Application for a non-material amendment following a grant of planning permission.
 Town and Country Planning Act 1990

TWO STOREY AND SINGLE STOREY REAR EXTENSIONS, HIPPED ROOF OVER FLAT ROOF AND FENESTRATION ALTERATIONS

DM/21/03347/FPA

REAR ELEVATION FENESTRATION CHANGED TO FACE BRICKWORK IN LIEU OF APPROVED RENDER, AND ADDITIONAL WINDOWS ADDED EITHER SIDE OF FRENCH DOORS.

PROJECT: PROPOSED ALTERATIONS TO WESTHOUSE FARM, GARMONDSWAY, BISHOP MIDDLEHAM, DURHAM DL17 9DY For Mr. & Mrs. P. MORGAN
 DRAWING TITLE: PROPOSED PLANS & ELEVATIONS.

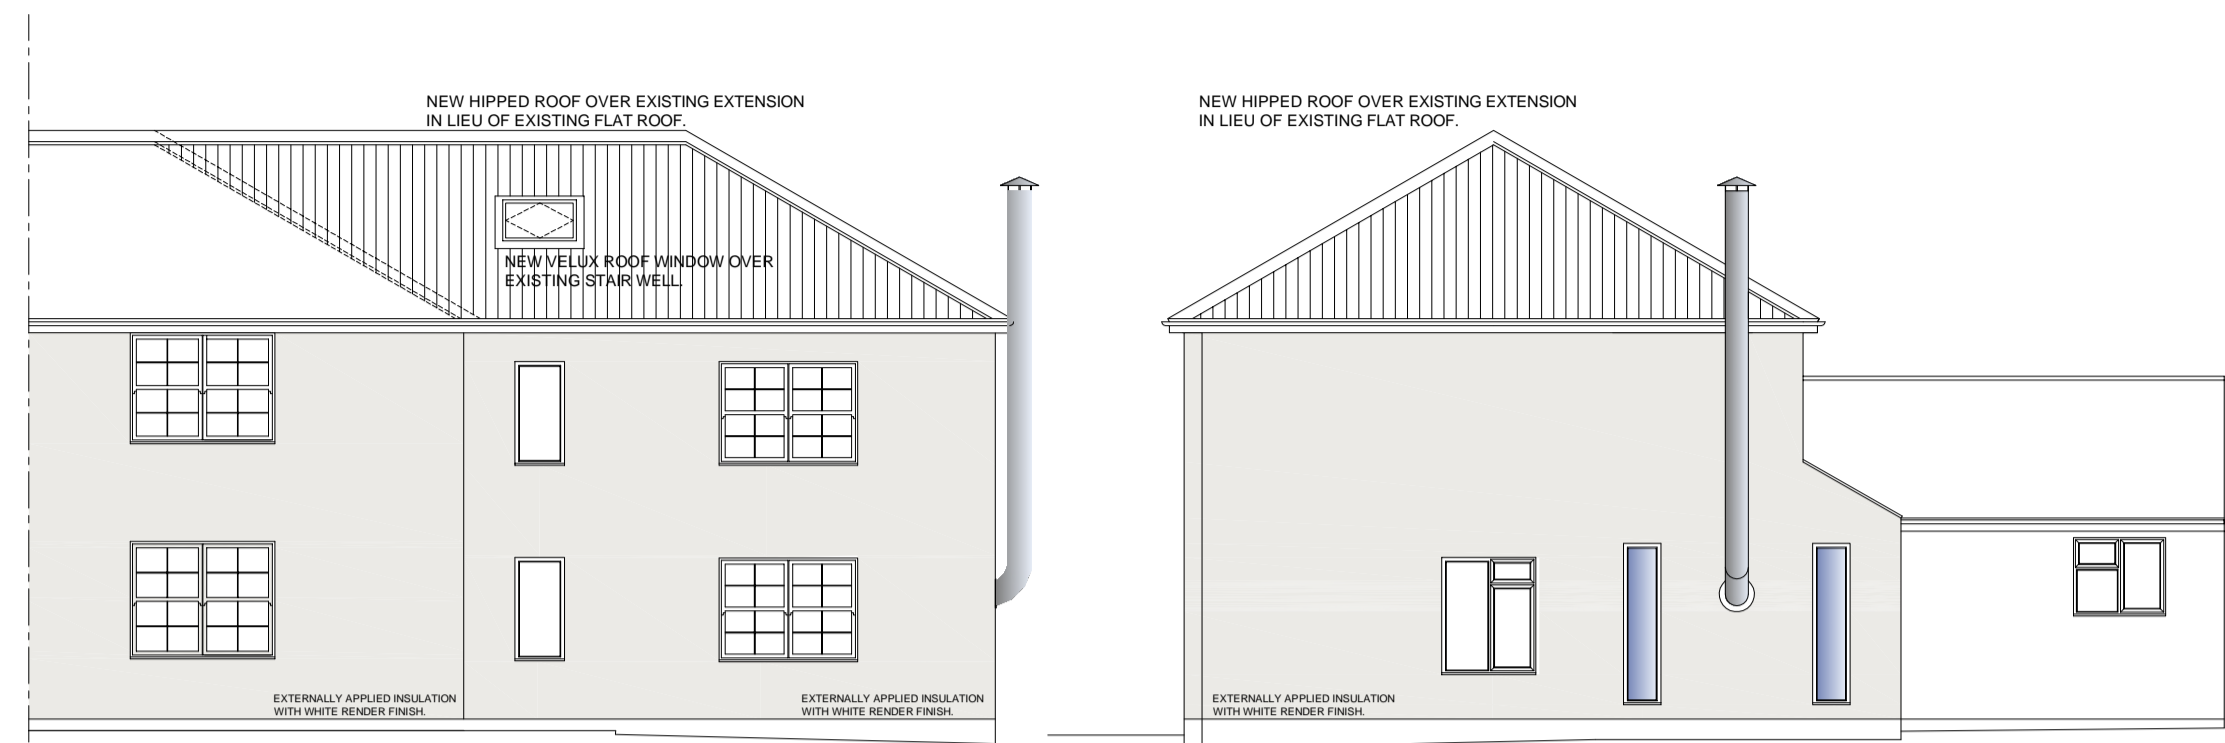
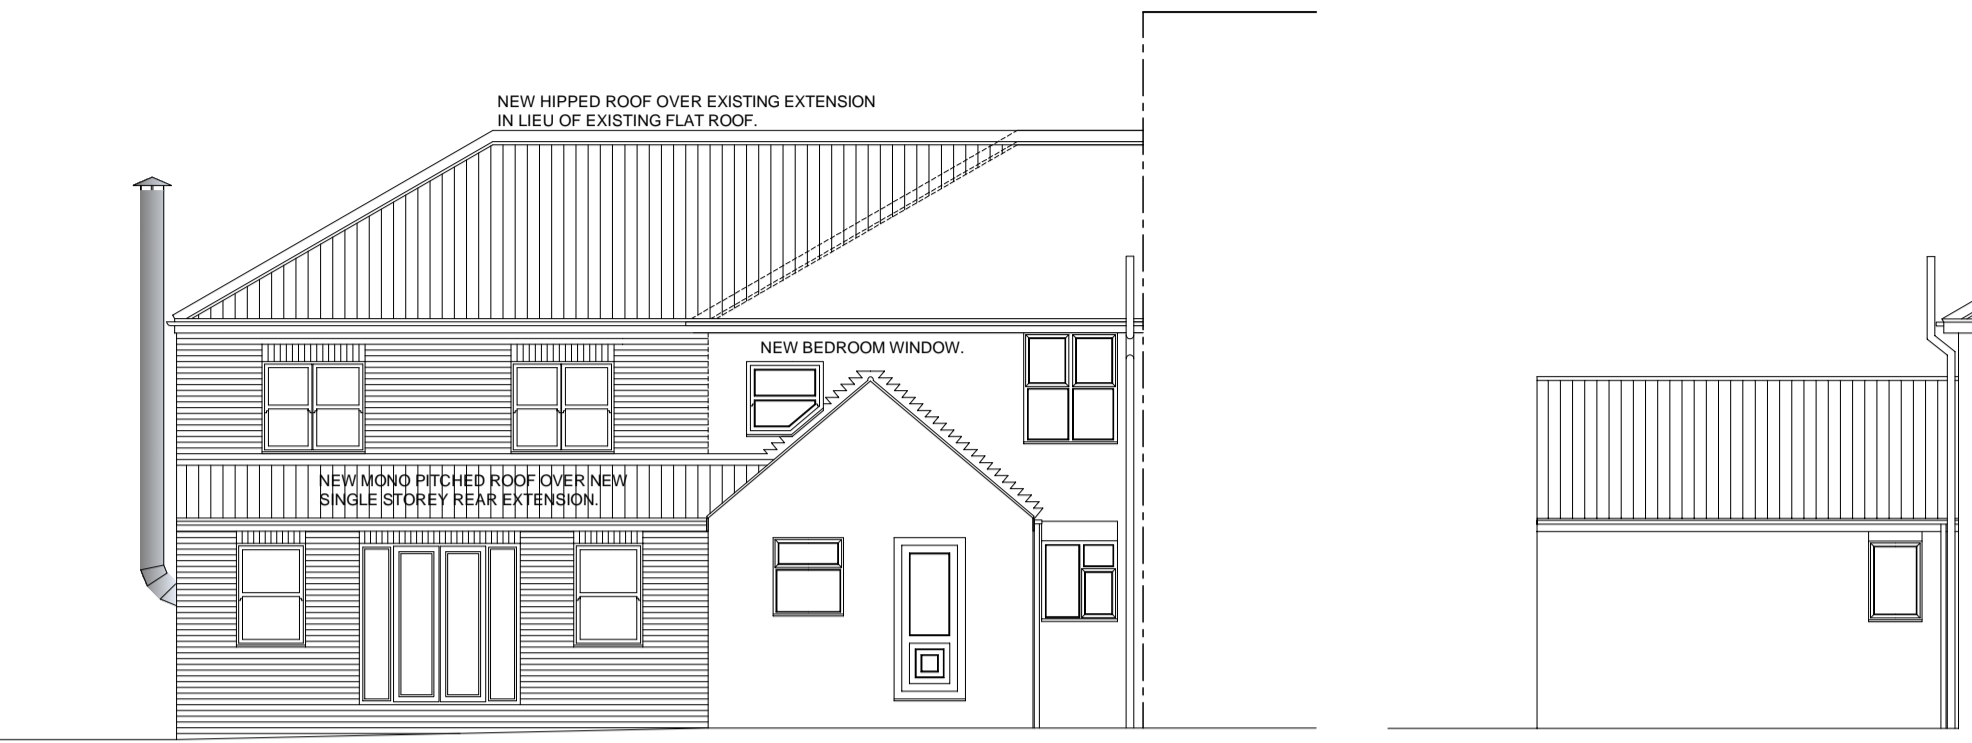
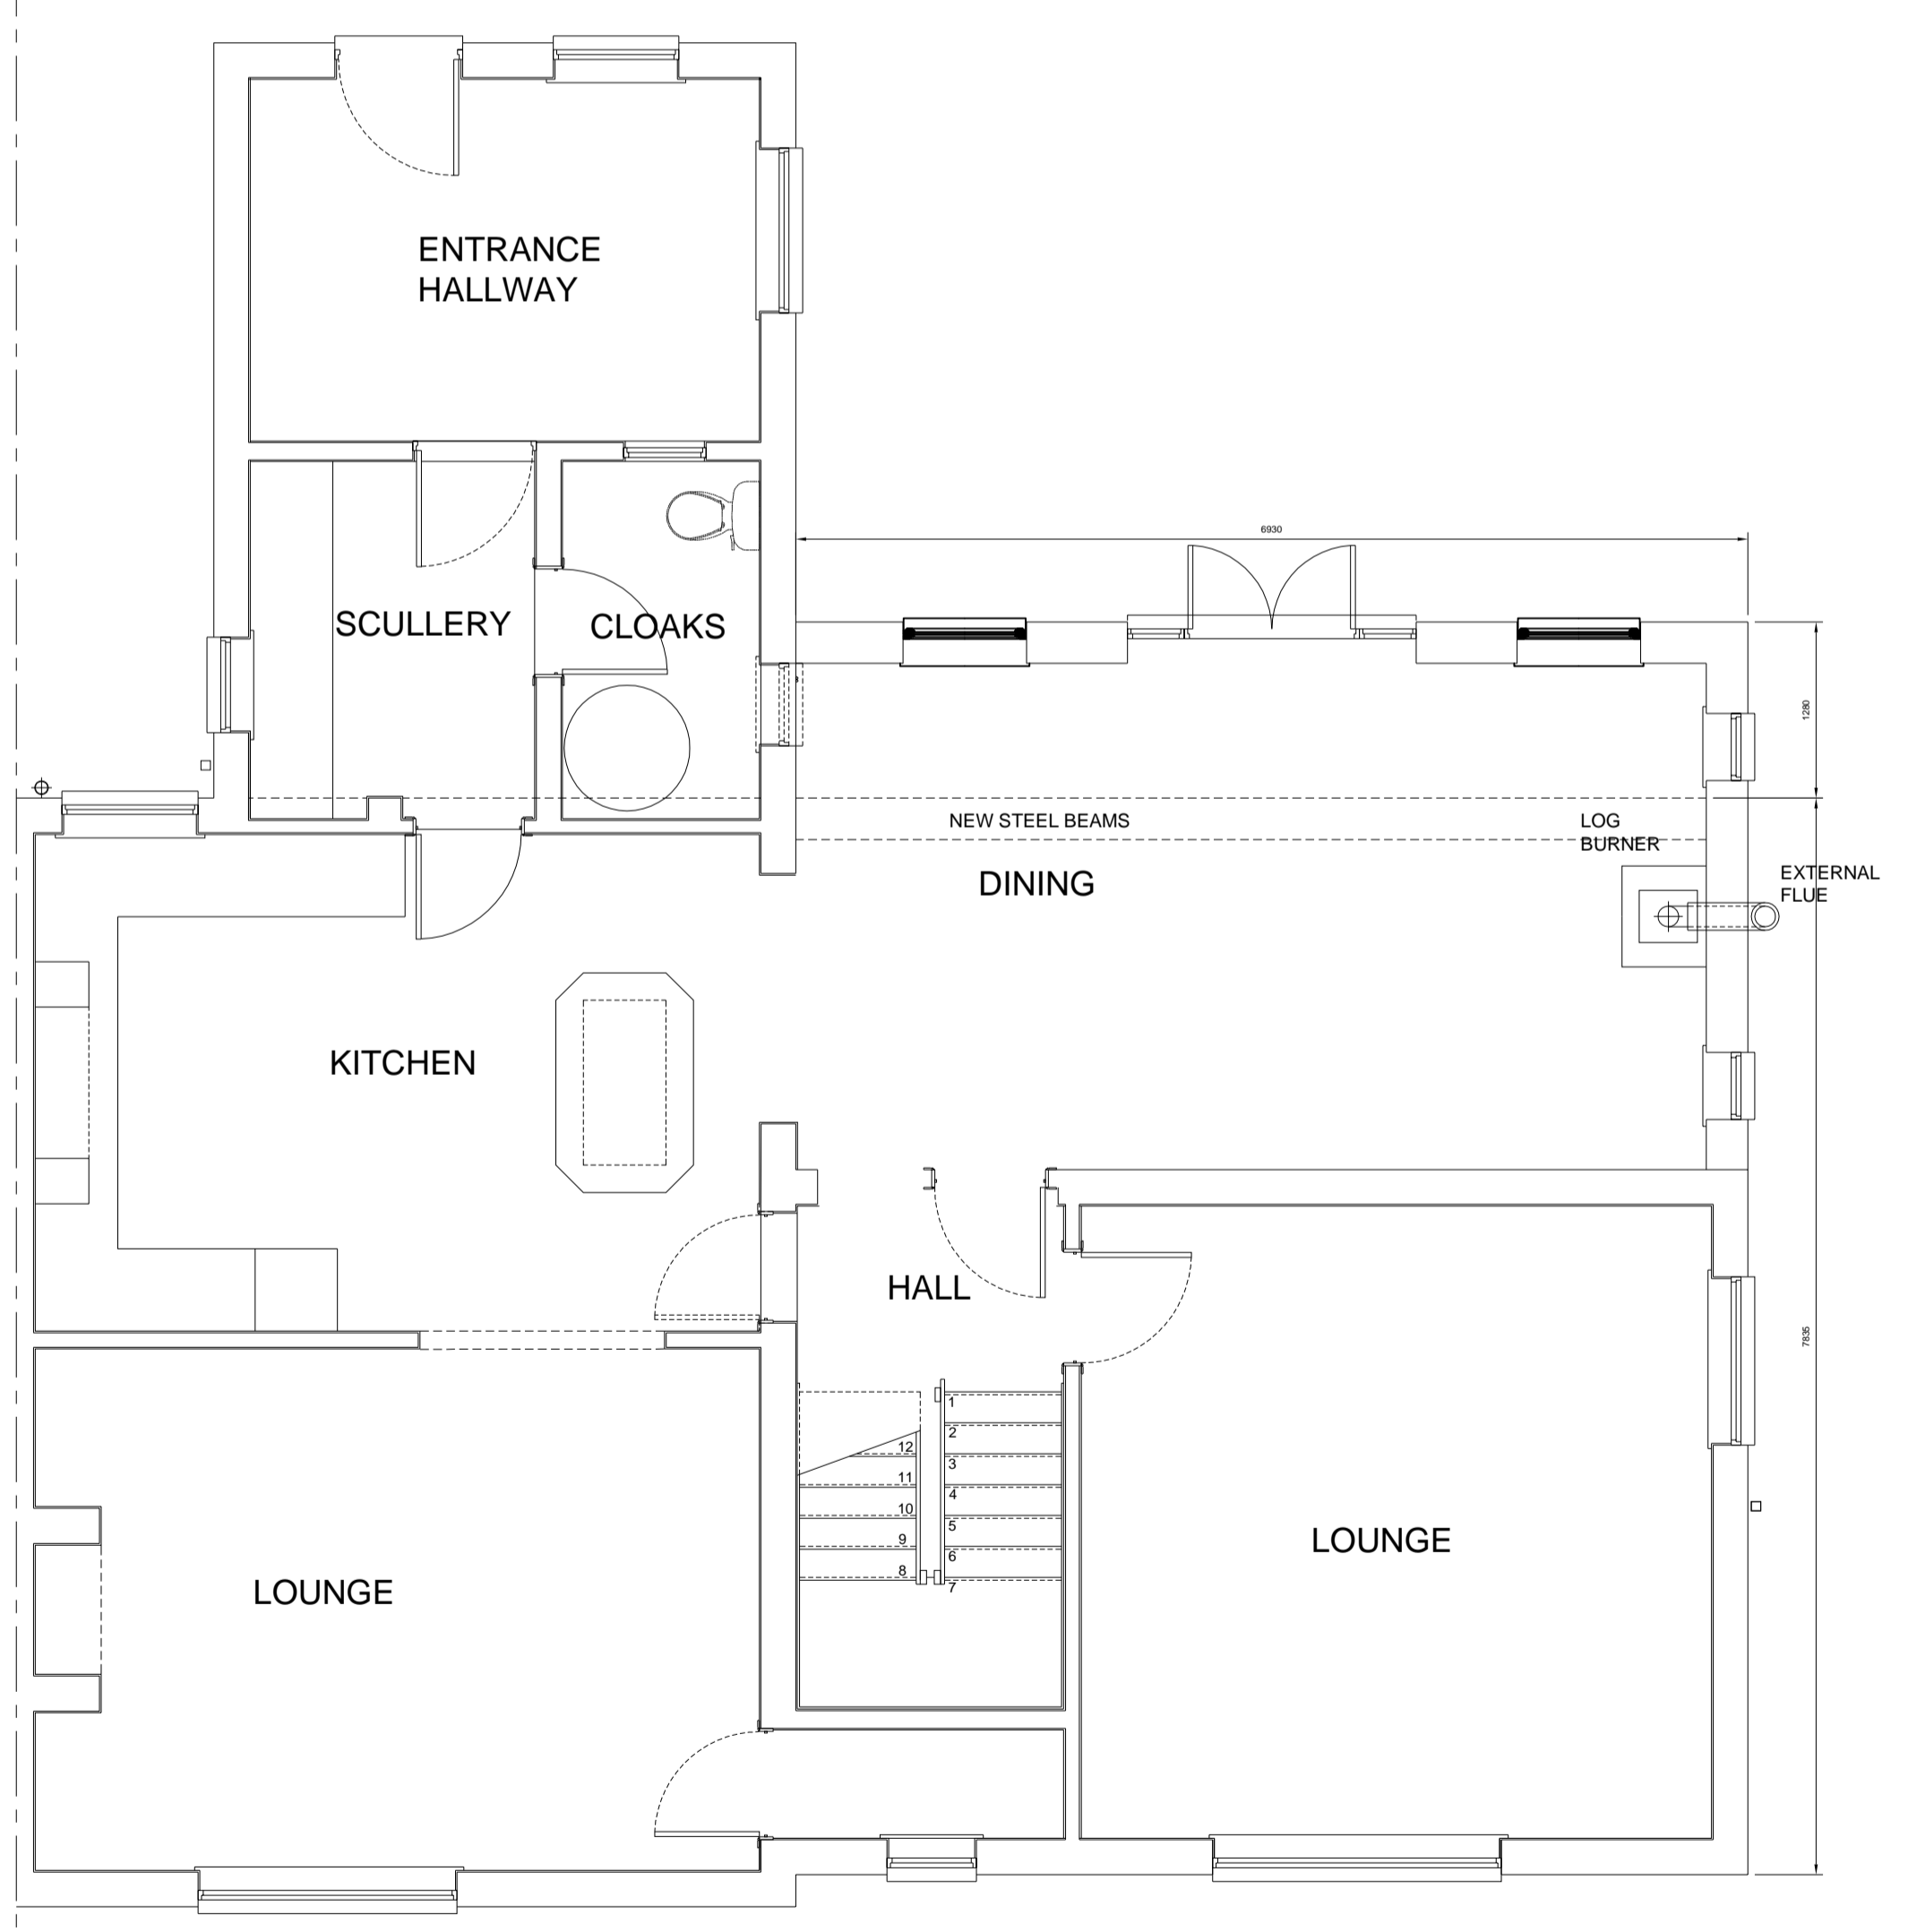
TO MATCH NEW REAR ELEVATION WITH EXISTING.
ADDITIONAL WINDOWS TO PROVIDE MORE NATURAL LIGHT TO DINING ROOM EXTENSION.
